## Response to Request for Information | SSD-87245208

This letter is prepared on behalf of 17 Oxford St Pty Ltd (the Applicant) in respect of SSD-87245208, a State Significant Development Application for a mixed-use development incorporating in-fill affordable housing at 13-15 and 17 Oxford Street and 2 Verona Street, Paddington.

Scale	Project No.	Dwg. No.	Issue
As Shown	25080	102	D

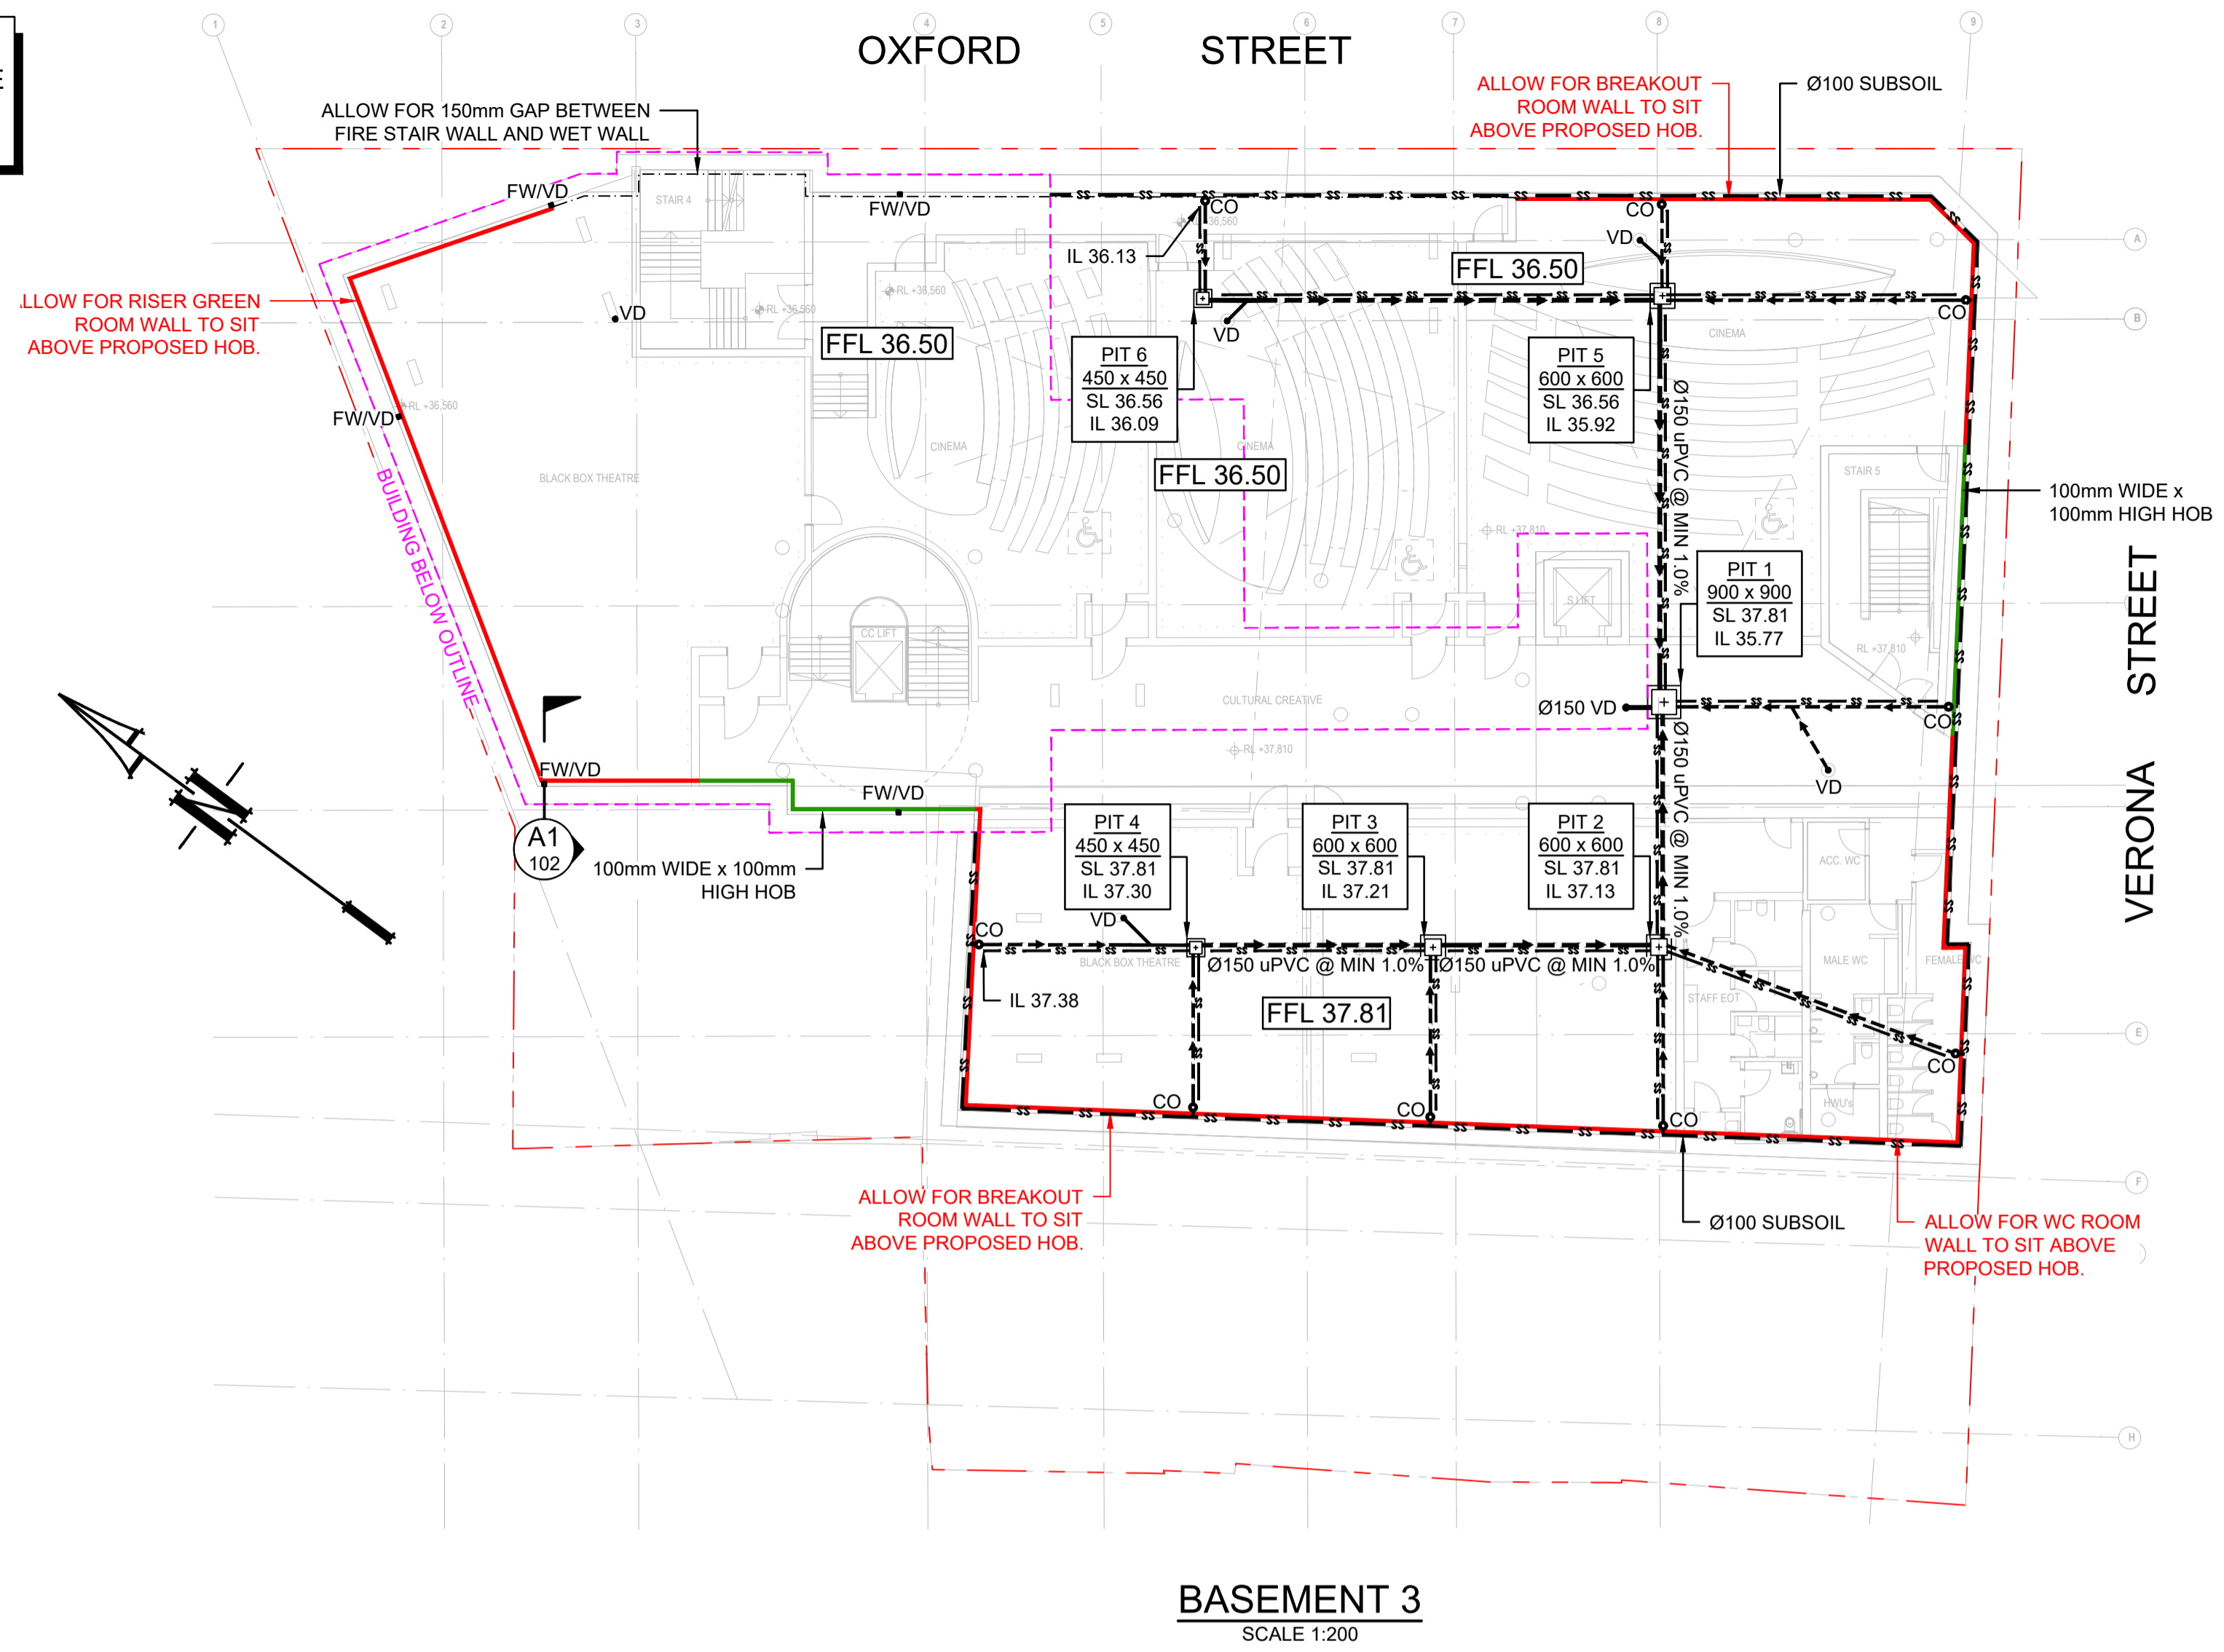
- Stormwater Pit 3 removed and associated pipe infrastructure redirected around the deep soil area, providing an unobstructed deep soil area.
- Drainage design revised so that emergency overflow from both OSDs is directed (via additional pipe infrastructure) to drain to a pit rather than freely discharging from the Level 1 elevation to the footpath.

## Appendix B **Alternative Ventilation Markup**

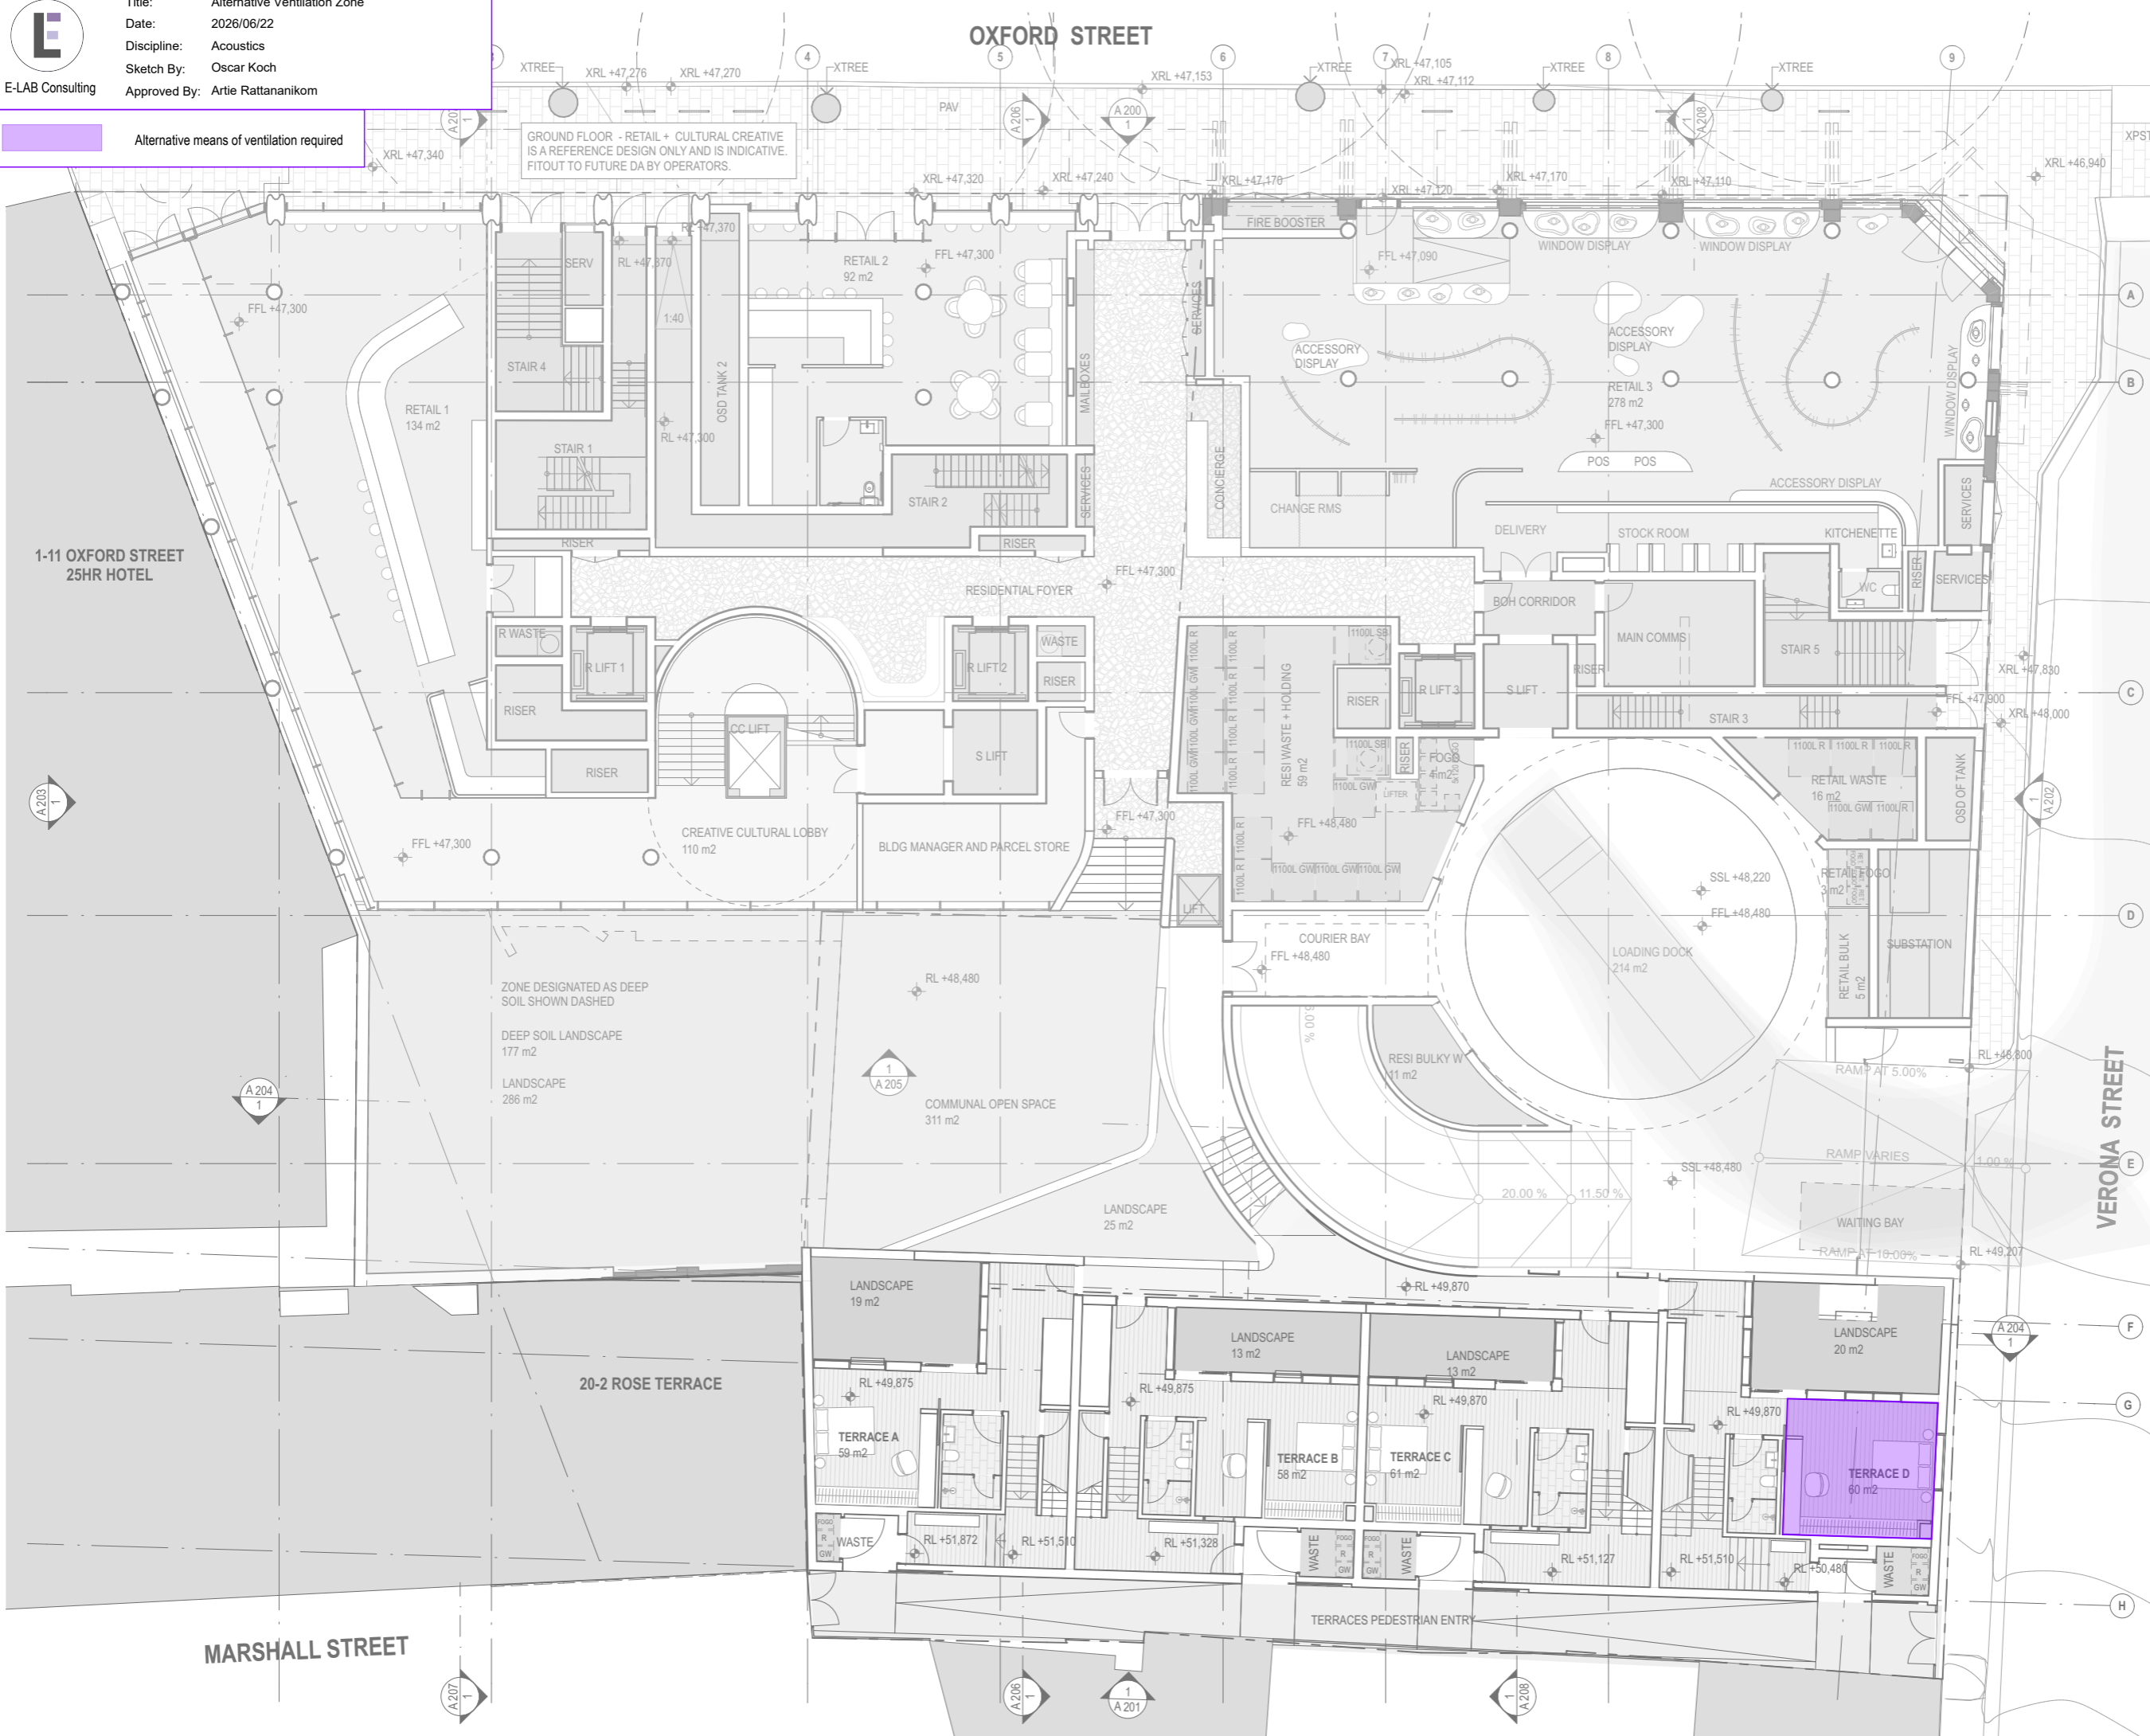
13. The requirement for all noise affected living spaces and bedrooms to have a passive means of natural ventilation in accordance with ADG Objective 4B-1 has not been addressed by the amended design.

The amended acoustic report confirms that many apartments will exceed internal noise limits in windows open scenarios. Air conditioning is still proposed to address ventilation which is not sufficient to provide adequate amenity, including natural ventilation and cross ventilation for residents. The financial implication of such an approach will also disproportionately impact the affordable housing residents.

The provision of mechanical ventilation as an alternative to open windows is consistent with the DPHI mandatory guideline for development adjacent to major roads (Development near Busy Roads and Rail Corridors, Section 3.6.1), which provides that where internal noise levels with windows open exceed the criteria by more than 10dB(A), the design should allow occupants to leave windows closed whilst still meeting NCC ventilation requirements.
